From: Michael Eastham
Sent: 12 February 2019 10:36
To: Planning.Responses
Subject: FW: Planning Consultation on: BE/135/18/PL

APPLICATION BE/135/18/PL

Site Address: Salt Box Field Land off Rowan Way Bognor Regis PO22 9NW

Client: LANDLINK ESTATES
Architect: MOUNTFORD PIGOTT
Project: SALTBOX SITE BOGNOR REGIS
Drawing Title: PHASE 1 DRAINAGE STRATEGY PLANNING SHET 2 OF 3

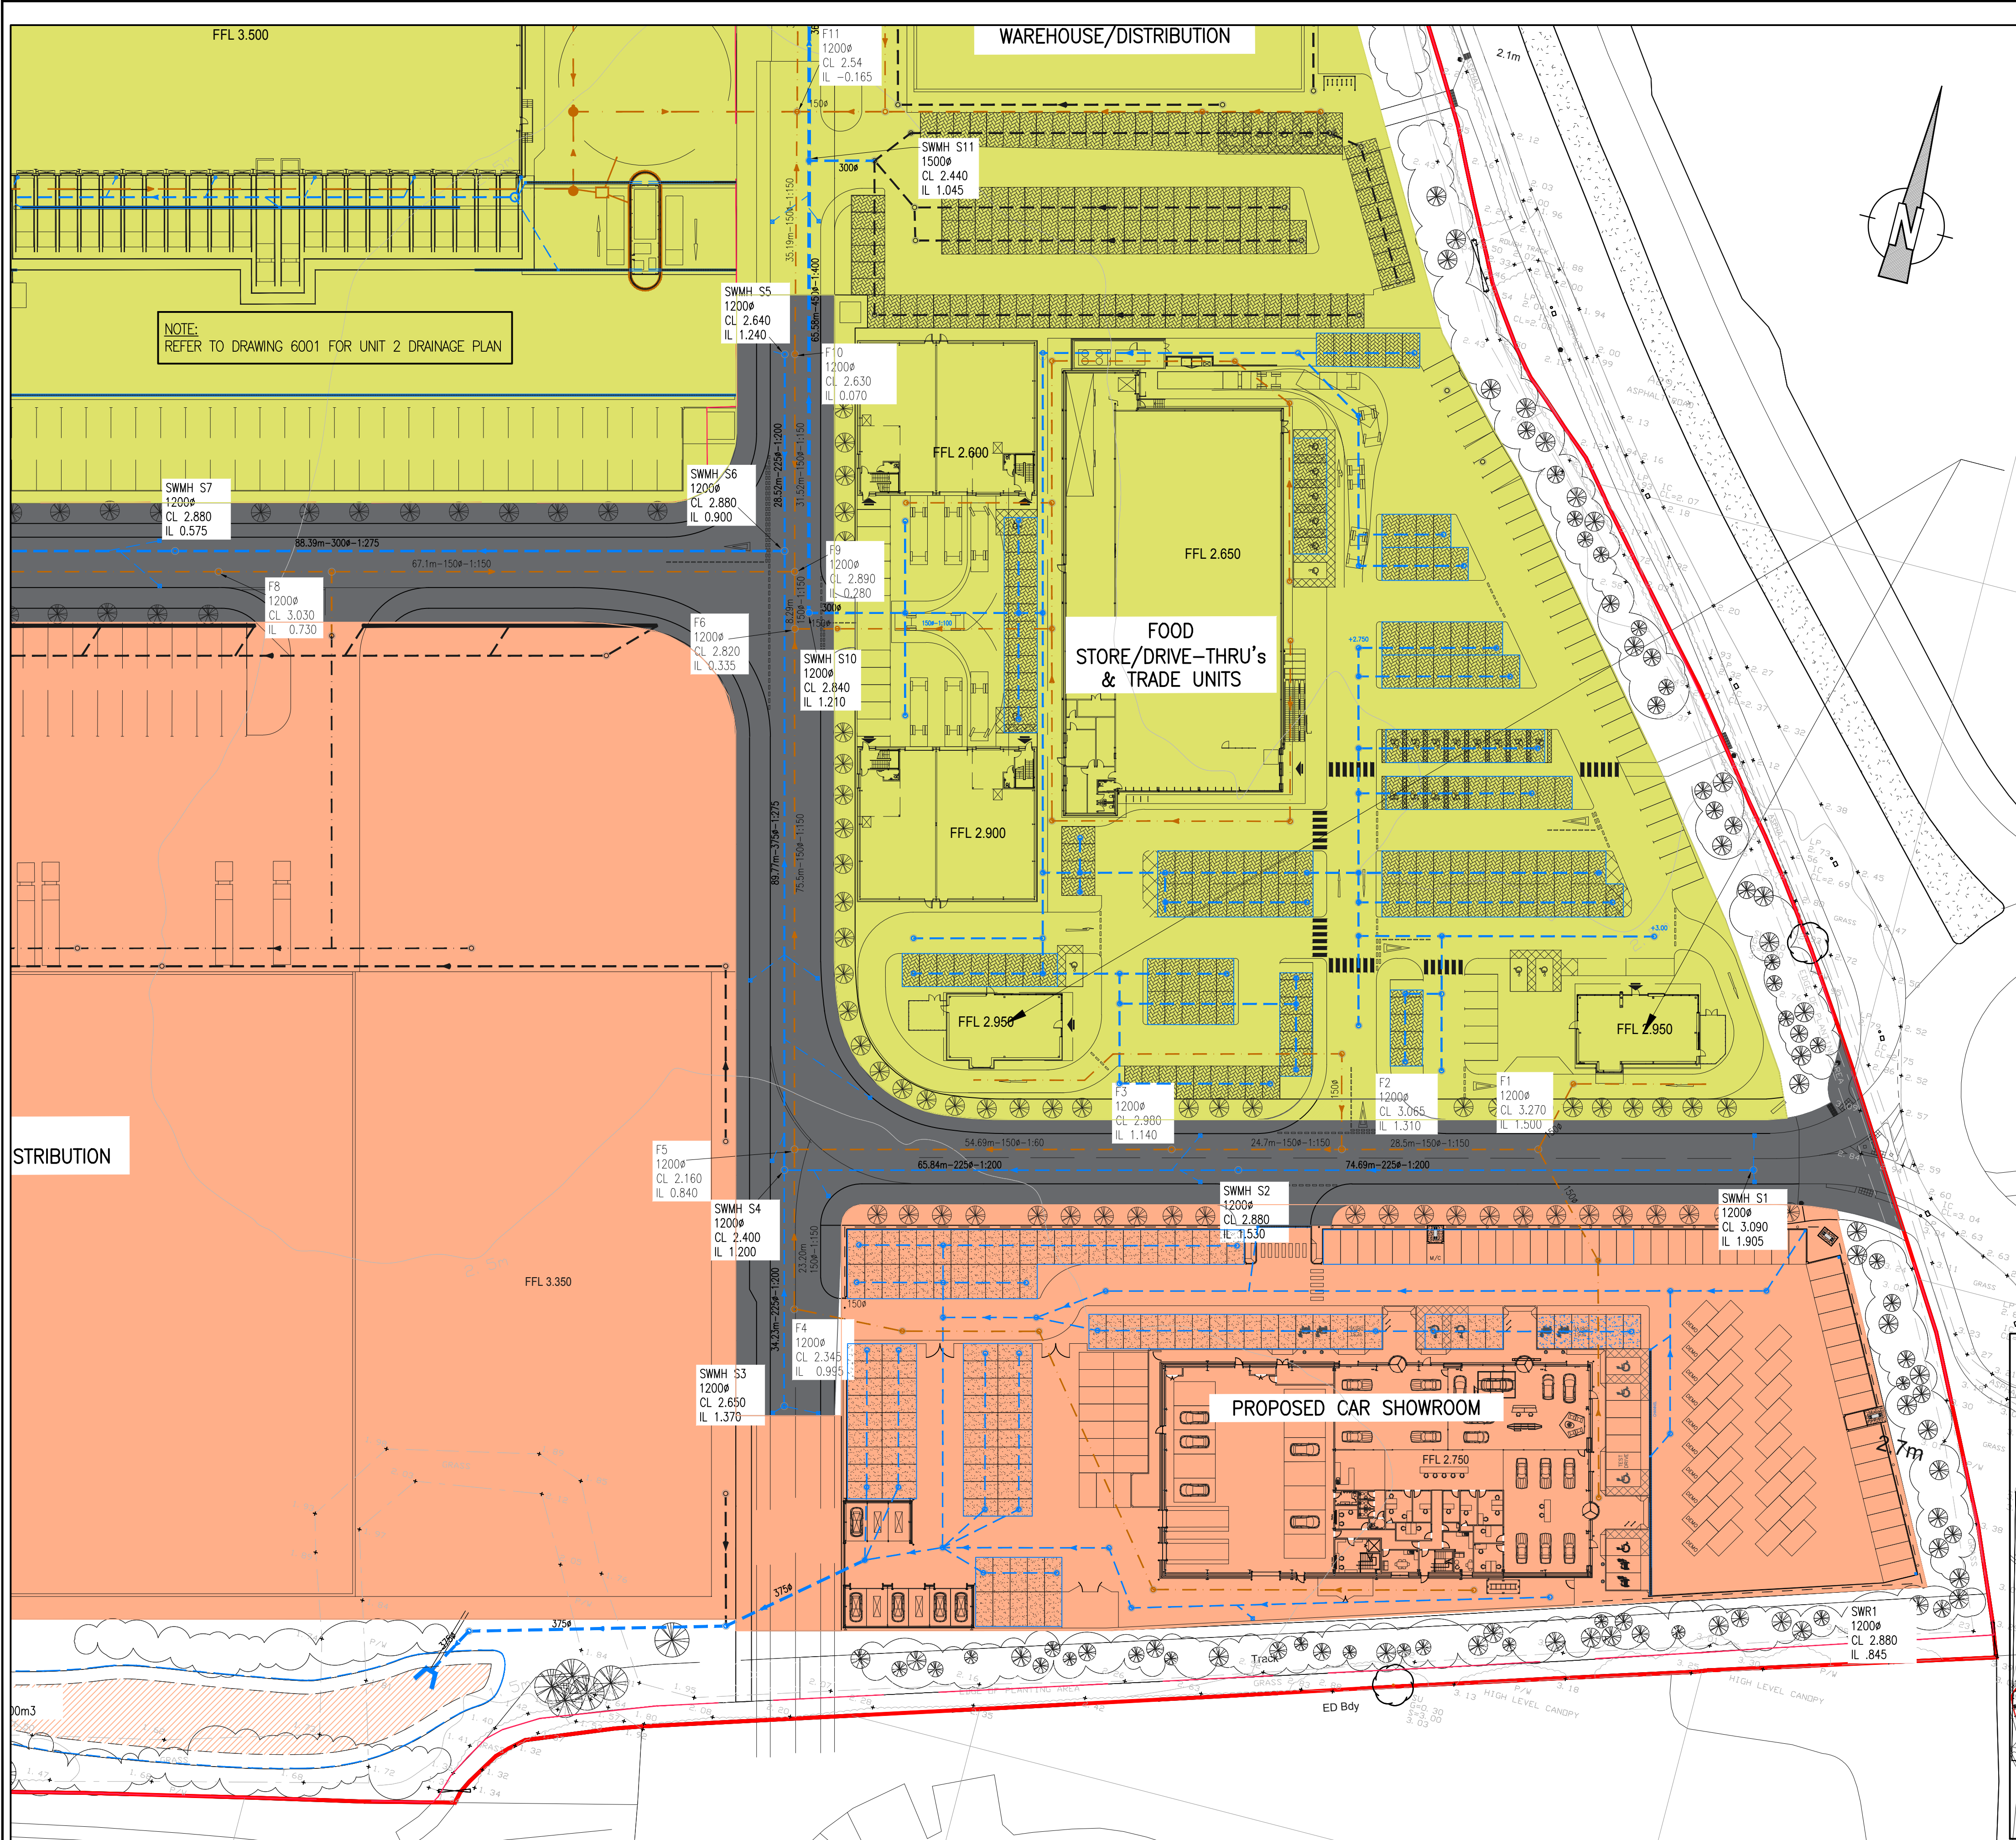
CIRIA C753 states that adequate treatment should be achieved before discharge of surface water, therefore your surface water drainage system should treat the water before discharge to watercourse or ground. Water naturally falls on the agricultural field at present, infiltration techniques would replicate this.

As long as adequate treatment is included within the surface water drainage design and given the fact that the site is not within a source protection zone I have no concerns regarding infiltration on pollution grounds.

As acknowledged within CIRIA C753 infiltration rates down to $1 \times 10^{-6} \text{ms}^{-1}$ are perfectly suitable for infiltration, hybrid systems can be looked at if half drain times turn out to be a concern.

Therefore, I again request that you complete shallow infiltration testing at depths associated with permeable paving.

It appears that only two infiltration test locations were used on this large site. One of these test pits gave results which do not prevent infiltration from being used. More infiltration tests must be completed, and some should be completed at shallower depths to determine if the use of permeable paving is appropriate.

It is unclear when infiltration testing was completed and it is evident that groundwater monitoring is still ongoing. Until the monitoring period is over and further winter infiltration testing has been completed it is not possible for me to determine if the drainage proposals are appropriate.

The proposals currently show that attenuation and controlled discharge to watercourse (both main river and ordinary watercourse) are proposed. No evidence has been submitted to demonstrate that infiltration is not viable.

Infiltration must be investigated.

The drainage proposal includes large car park areas of non-infiltration porous paving on Units 1, 2, 3, food store/drive-throughs and car show room areas, full retention petrol interceptor on unit 2 and road gullies with sump on the main access road (see drainage strategy drawings 6201-6203).

All these devices clean the surface water before it discharges into the water course at a restricted rate that provides 70% betterment for 1 in 30 and 1 in 100 year rainfall events compared to the greenfield run off rate of the site (see extract from the FRA attached).

The environment agency advice against infiltration because of shallow groundwater and high risk of pollution to controlled waters.
